HINCKLEY NATIONAL RAIL FREIGHT INTERCHANGE

Project reference TR050007

Applicant's Response to Deadline 4 Submissions [part 8 – Parish Councils]

9 February 2024

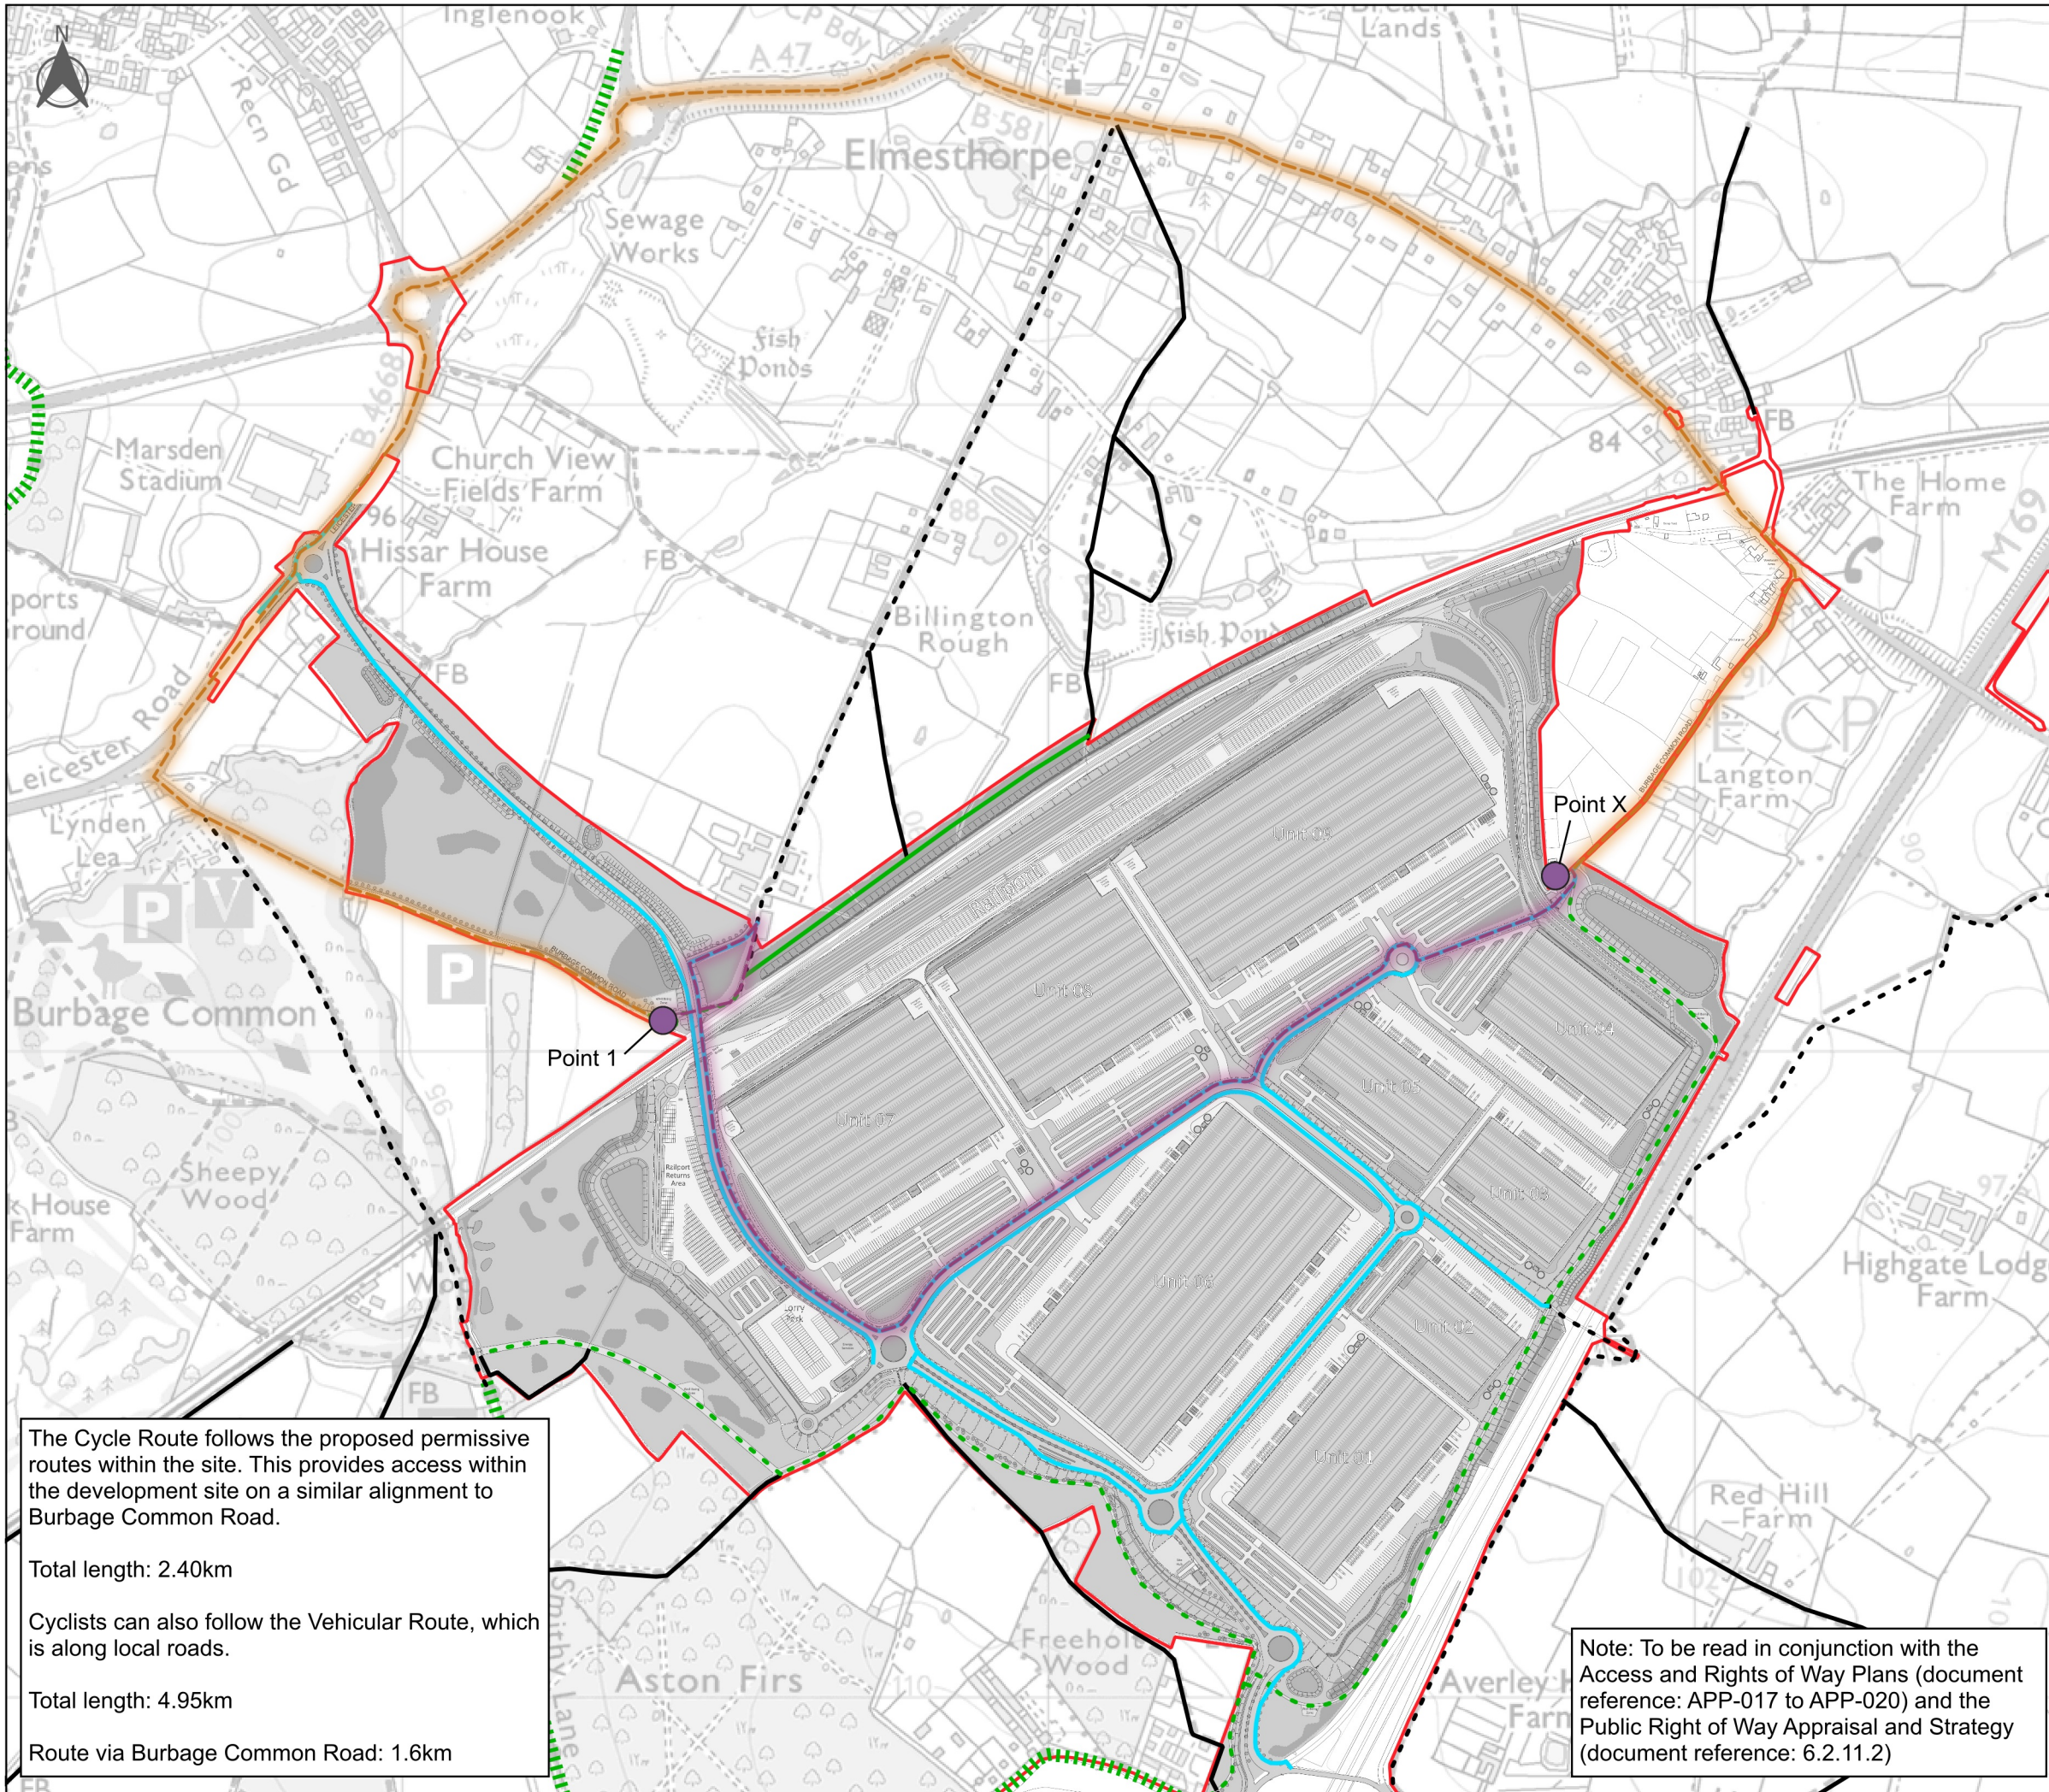
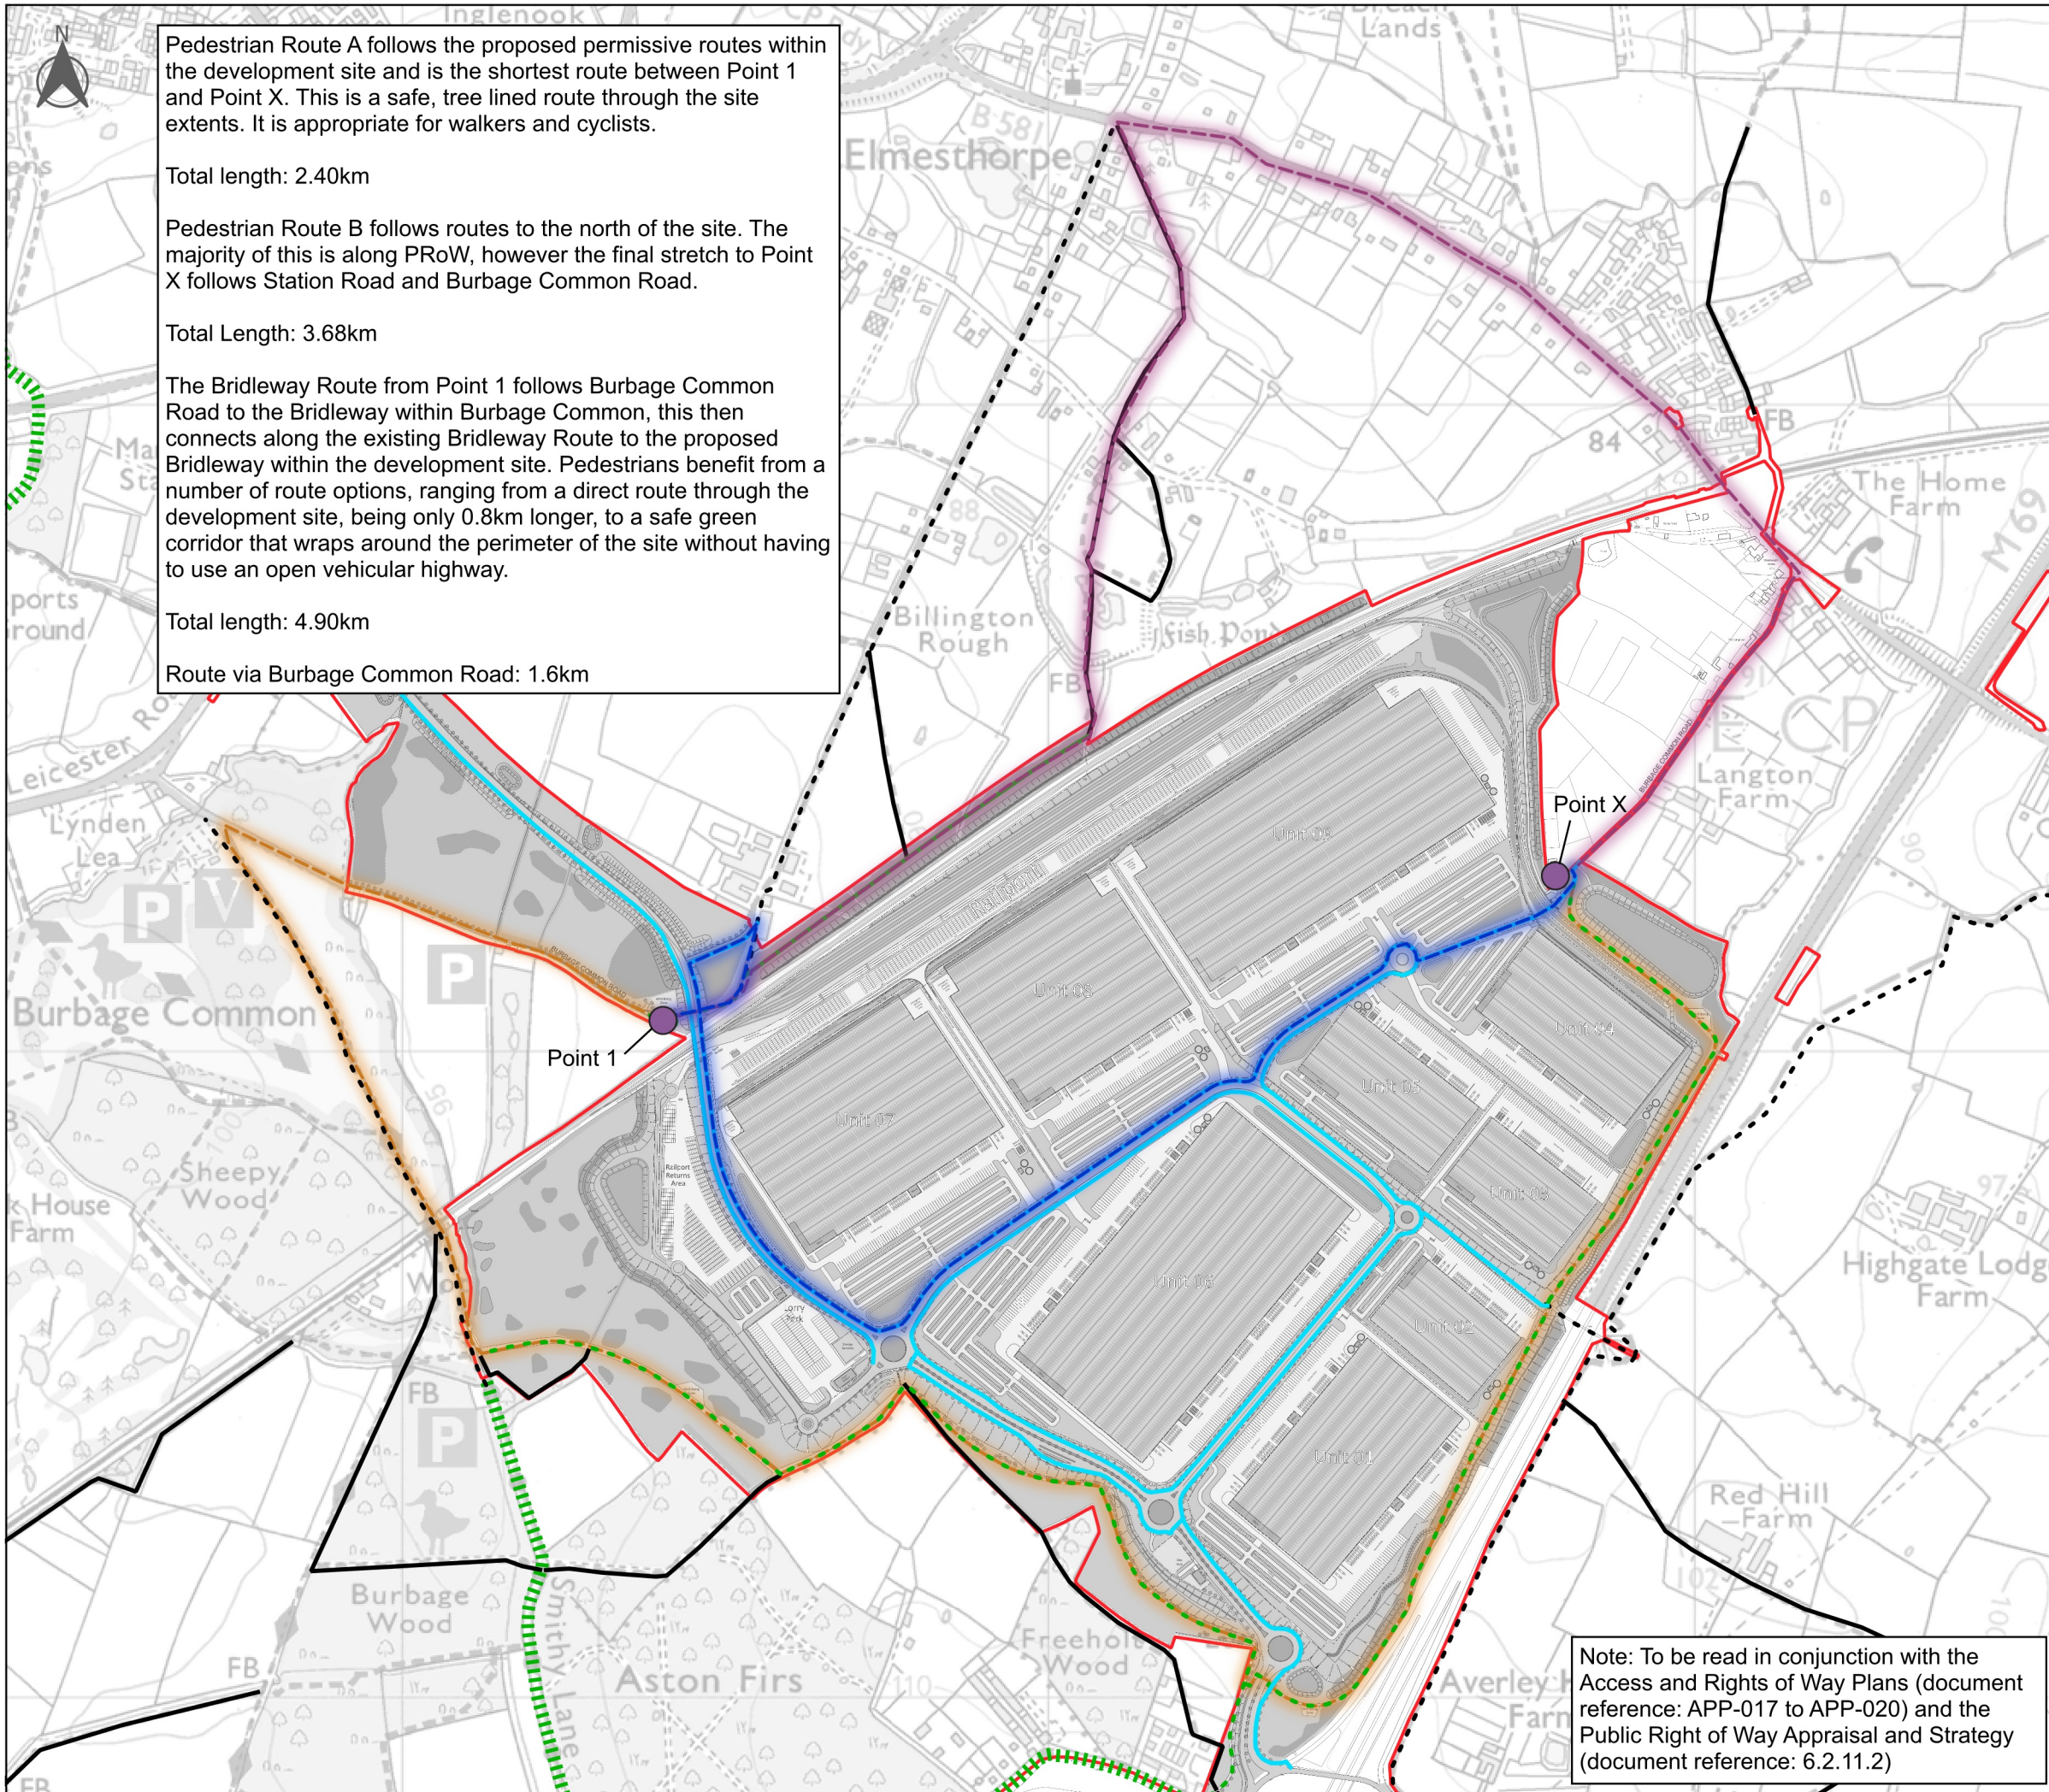
2	1.11.32	<p>Effect on users of Burbage Common Road</p> <p>In the response dealing with the distances between points 1 and X on the Access and Rights of Way Plan (2.3A and 2.3B), the Applicant has referred to users being able to use permissive ways (comment in 'Alternative route' for Walkers in [REP3-054]. b) Could the Applicant please explain how, in line with paragraph 5.216 of the NPSNN, the routes and measures being secured would meet the strong</p>	<p>Burbage Common Road is the main link from Elmesthorpe to the beloved Burbage Common and Woods SSSI (including Elmesthorpe Plantation). Many residents use this road to walk for leisure, or to exercise their dogs/other animals. Burbage Common Road, whilst it is a road accessible for vehicles, is mainly used for access to business on Burbage Common Road, agricultural vehicles, as a bridlepath for equestrian users or by those with mobility scooters/wheelchairs/prams to access Burbage Common or enjoy the surrounding countryside, without having to traverse alongside the very busy A47/B4668 or along</p>	<p>The route between points 1 and X identified for cyclists, to the south of the railway bridge (the majority of its length) will be lit. The effects of this are considered in the environmental assessment. Lighting for security purposes will be provided within the new underpasses. It should be noted that the proposed route between points 1 and X provides a higher quality route than at present as it is segregated from vehicular traffic and well illuminated for the majority of its length contrary to Burbage Common Road. At the A47 link road/B4668 junction, a crossing point is provided between the shared footway cycleway on the link road and the shared footway/cycleway</p>
